Date: 26 November 2021

The Examining Authority's Schedule of changes to the Applicant's draft Development Consent Order

Application by National Highways for an Order Granting Development Consent for the A47 Blofield to North Burlingham scheme

DRAWING TITLE
WORKS PLANS REGULATION 5(2)(j) SHEET 2 OF 8

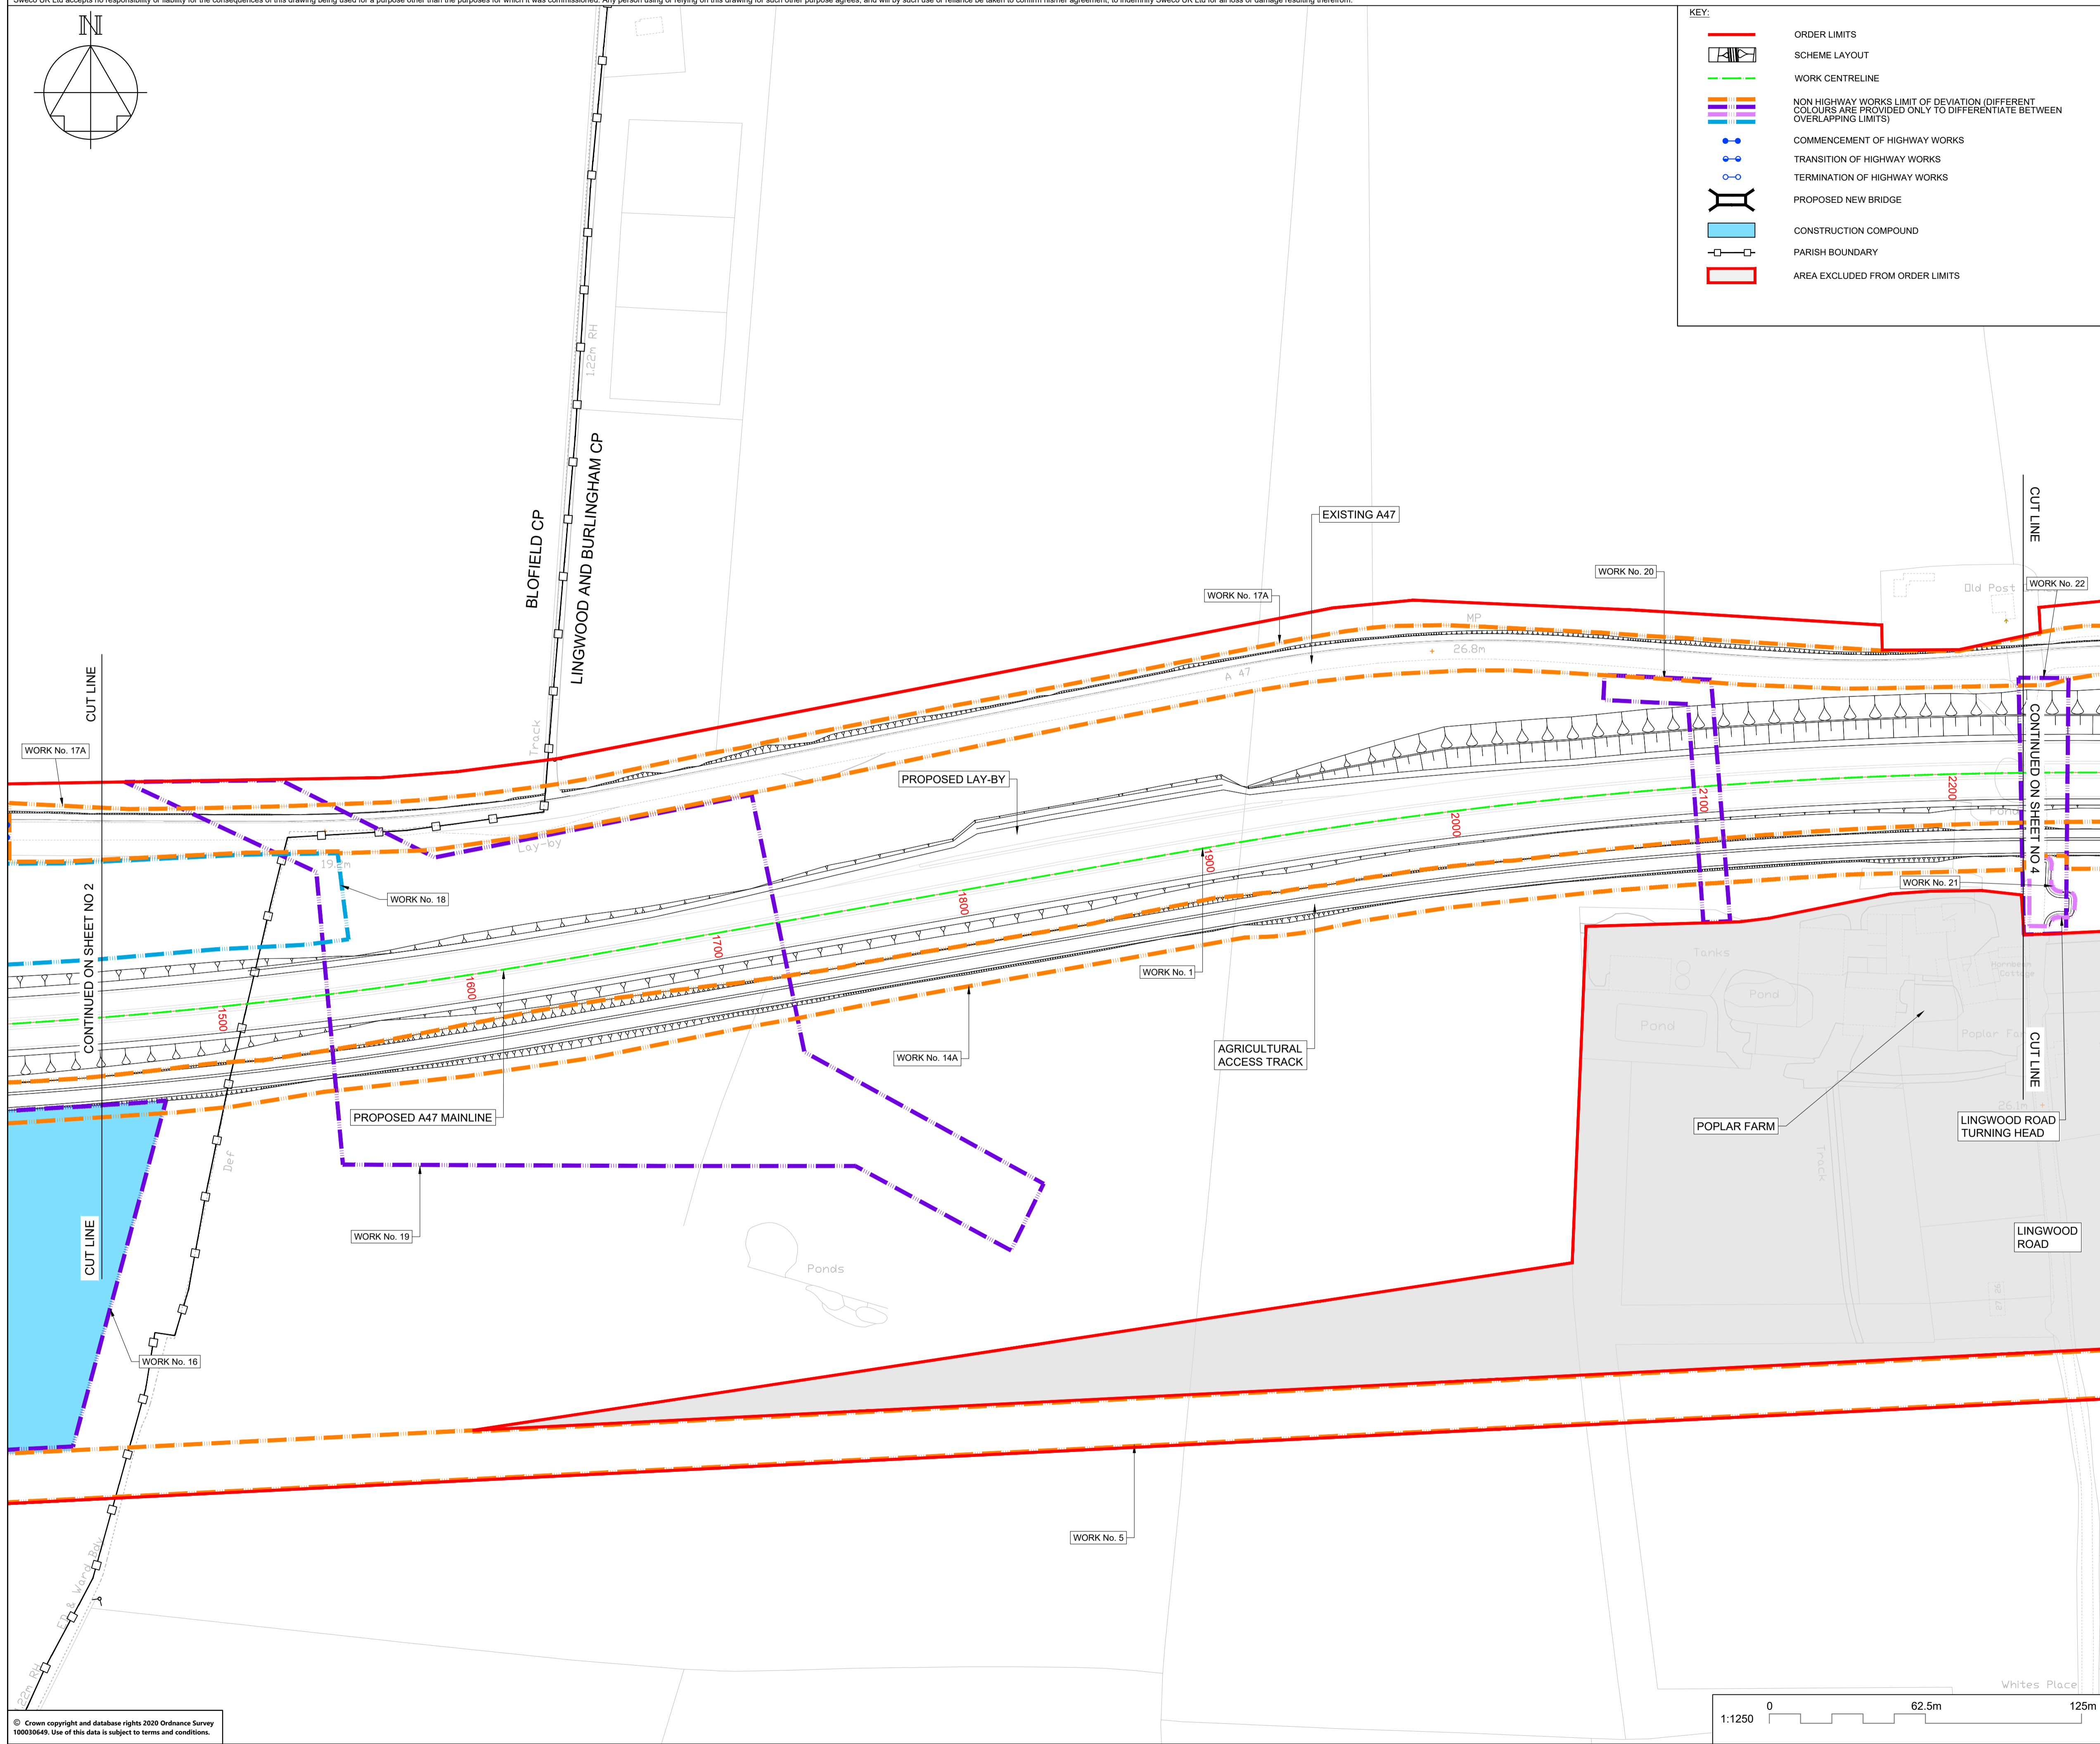
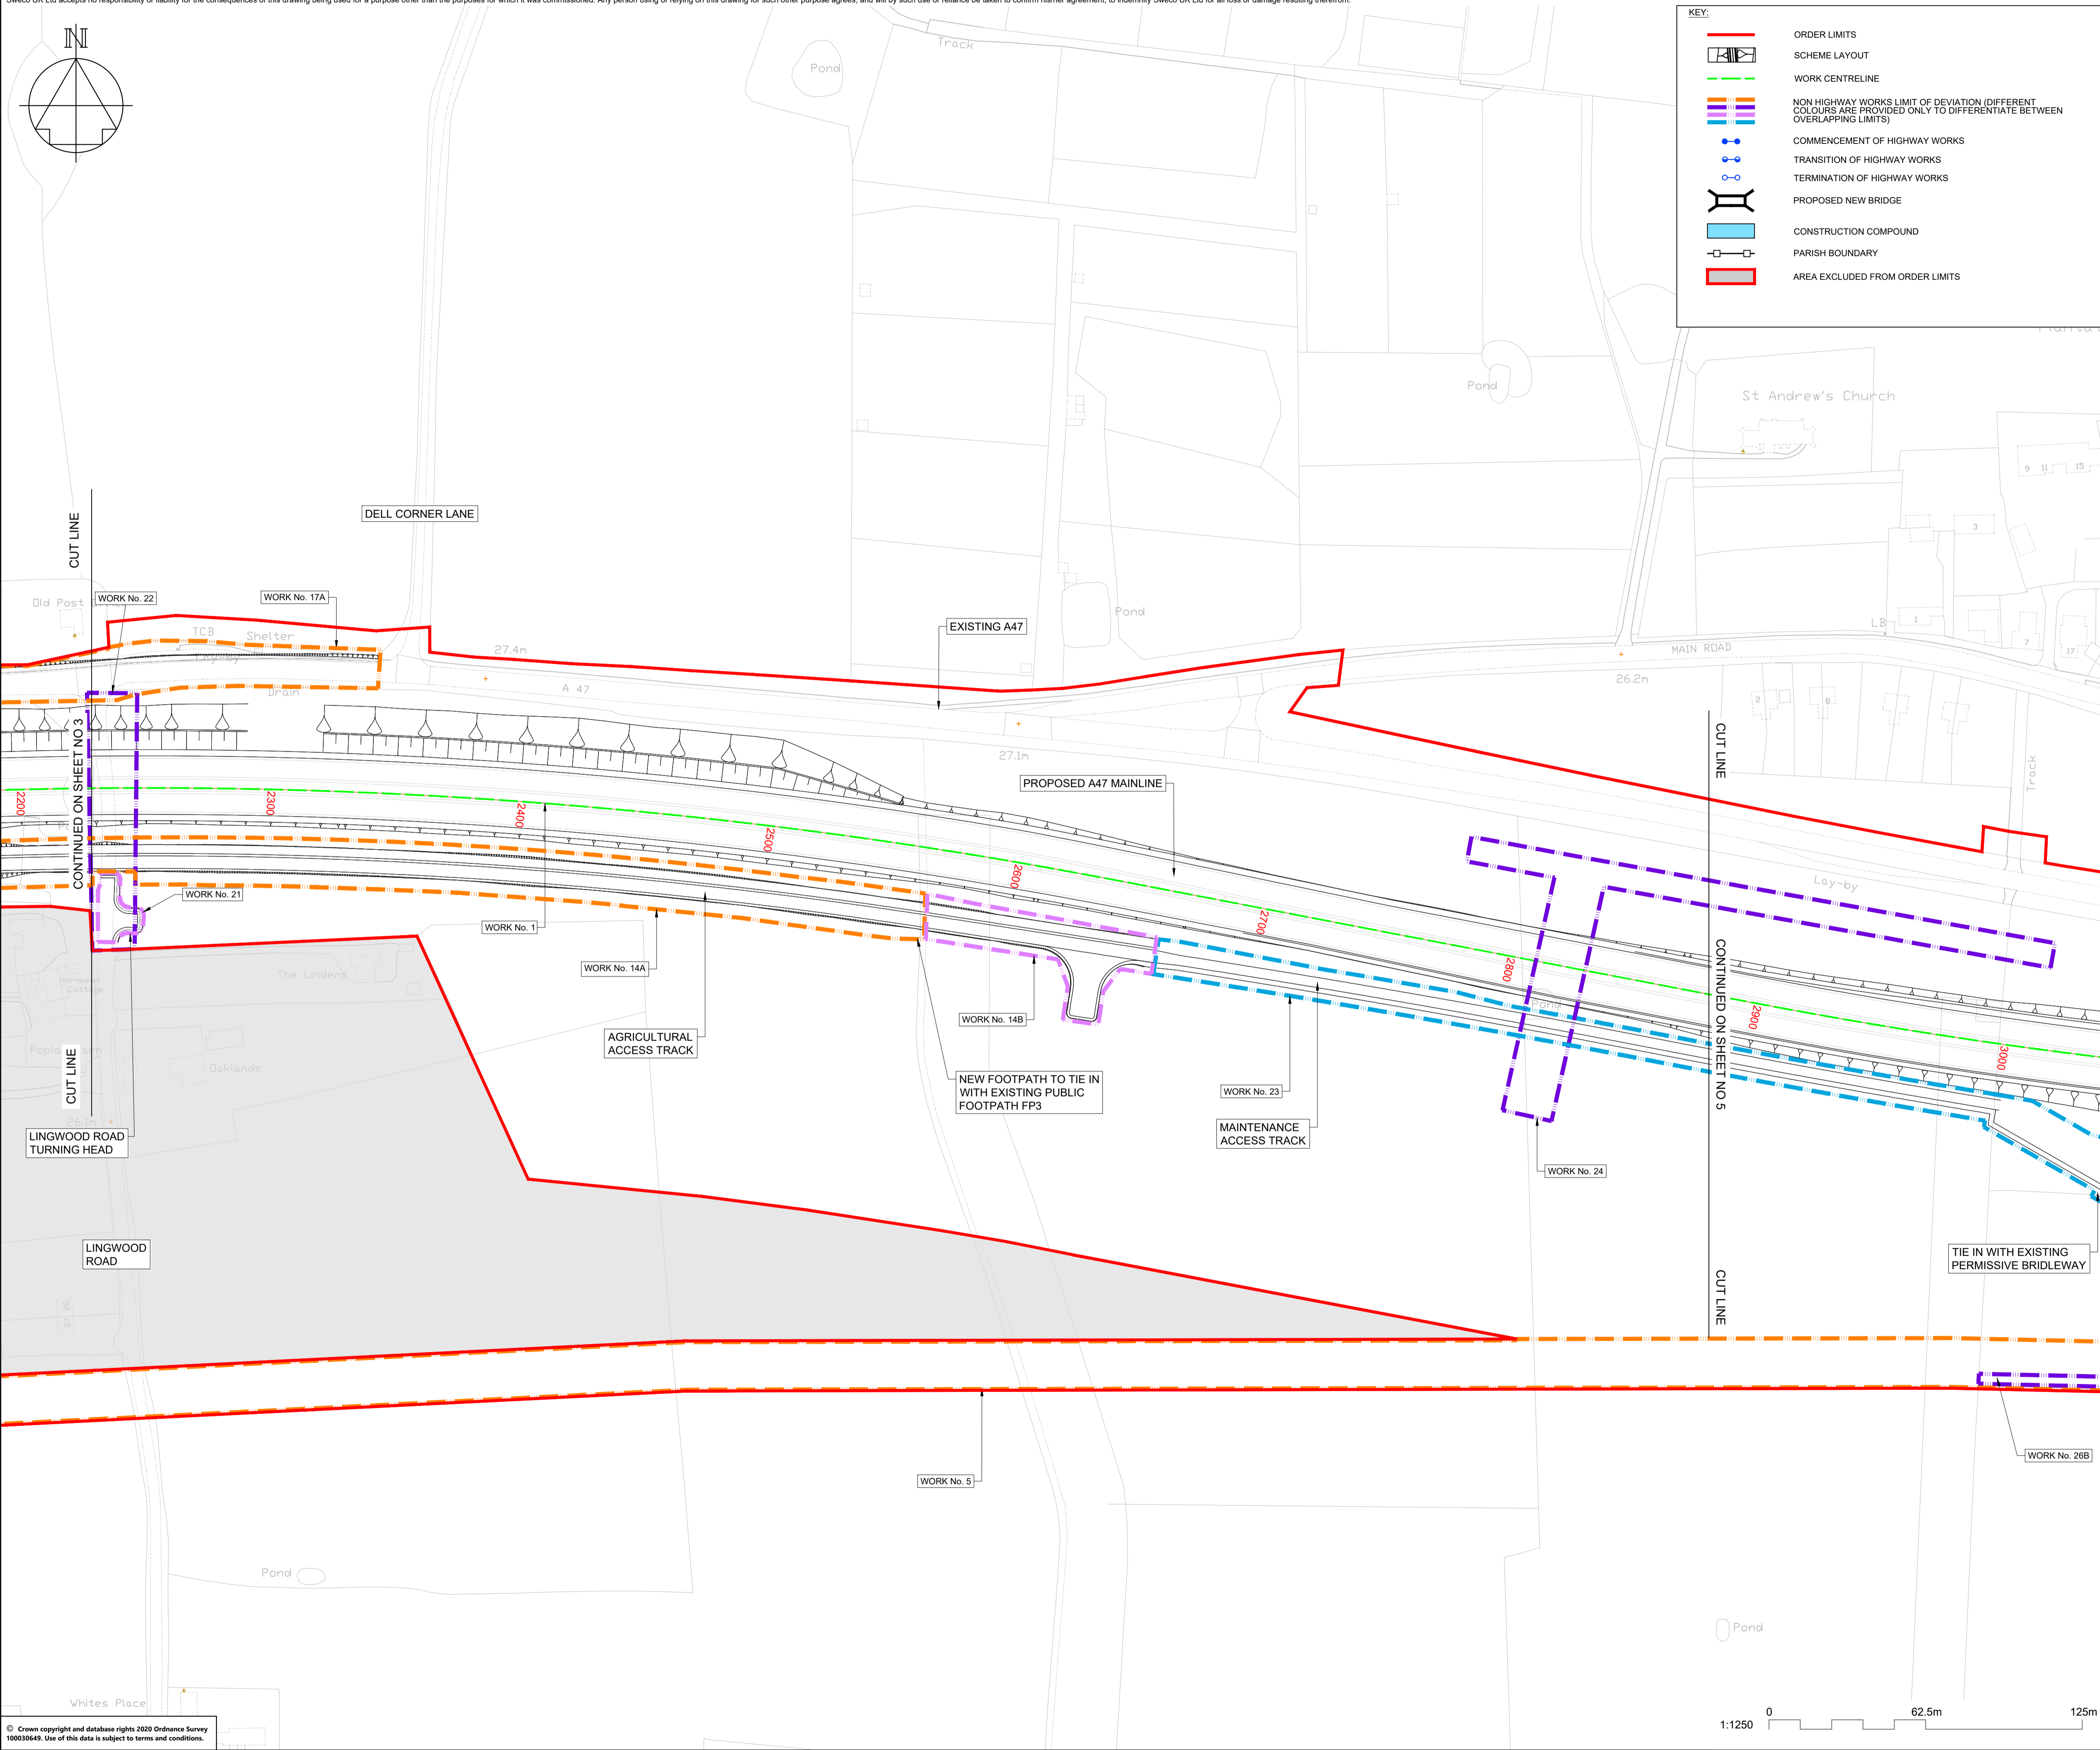
<p>the other) by the President of the Institution of Civil Engineers.</p> <p>(2) This article does not apply where any difference under any provision of this Order is between any person and the Secretary of State.</p>	
Schedule 1	Work No. 6 – new car park (of approximately 25 spaces) for Blofield Allotments including access to Work No. 7, together with a field access to Work No. 7, south of Work No. 7 and shown on sheet number 1 of the works plans;	For consistency with how other work numbers are written.
Schedule 1	Work No. 10 – improvements to Waterlow including new junction with Work No. 7, 307 metres east of Yarmouth Road, Blofield, and south of Work nNo. 7, shown on sheet number 2 of the works plans;	For consistency with how other work numbers are written.
Schedule 1	Work No. 18 – drainage and soakaway to the east of the Blofield Overbridge (Work nNo. 15) and north of Work No. 1 shown on sheet numbers 2 and 3 of the works plans;	For consistency with how other work numbers are written.
